Appendix 15.4: Stage 1 Road Safety Audit and Review

Proposed Upperchurch Windfarm Grid Connection (UWF Grid Connection), County Tipperary

Stage 1 Road Safety Audit and Review

> Project No.: 20815 Document No.: 6001/Rev.B Date: October 2019

### Raising Road Surface Levels at W7, W36 and W53

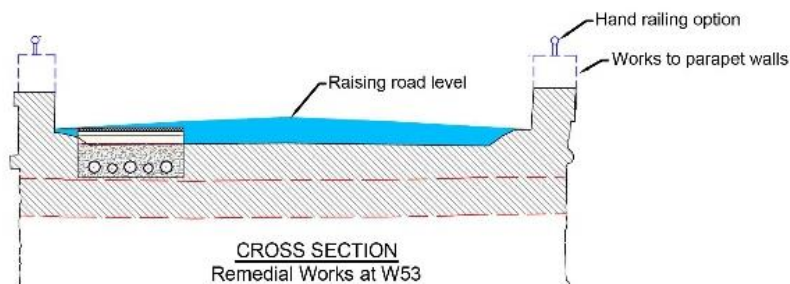
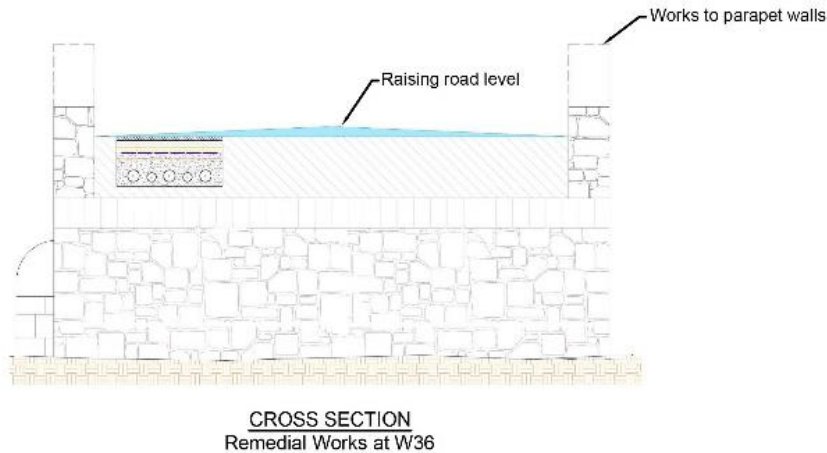
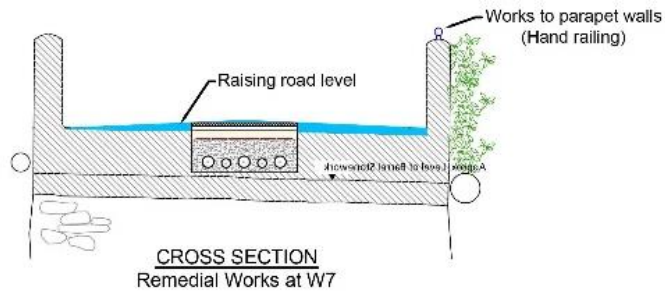
There are no details of the vertical levels proposed at the tie-ins, with the existing L2156-0 road pavement surface, at either end of the proposed road pavement reinstatement and build up. The risks are that tie-ins without appropriate transition could result in sharp ramped edges, and consequent possible damage to vehicles and to the road pavement; and result in inadequate drainage, with ponding and ice during cold weather, and consequent potential skidding, collisions and injuries.

Provide appropriate vertical tie-ins and transitions, maintaining the existing drainage from north to south along the L2156-0 across the bridge.

There are no details of the vertical levels proposed at the tie-ins with the existing R503 road pavement surface at either end of the proposed road pavement reinstatement and build up. The risks are that tie-ins without appropriate transition could result in sharp ramped edges, and consequent possible damage to vehicles and to the road pavement; and result in inadequate drainage, with ponding and ice during cold weather, and consequent potential skidding, collisions and injuries.

Provide appropriate vertical tie-ins and transitions, maintaining the existing drainage along the R503 from the approximate centre of the bridge to both ends, with appropriate tie-ins with the existing adjacent accesses.

There are no details of the vertical levels proposed at the tie-ins with the existing R503 road pavement surface at either end of the proposed road pavement reinstatement and build up. The risks are that tie-ins without appropriate transition could result in sharp ramped edges, and consequent possible damage to vehicles and to the road pavement; and result in inadequate drainage, with ponding and ice during cold weather, and consequent potential skidding, collisions and injuries.

Provide appropriate vertical tie-ins and transitions, maintaining the existing drainage along the R503 from the approximate centre of the bridge to both ends.

Ecopower Developments Response: Drawing "05652-545_Bridge 2 (W7)" attached showing vertical levels at Tie-Ins.

Ecopower Developments Response: Drawing "05652-525_Bridge 11 (W36)" attached showing vertical levels at Tie-Ins.

Ecopower Developments Response: Drawing "05652-536_Bridge 15 (W53) Sh 2 of 2" attached showing vertical levels at Tie-Ins.
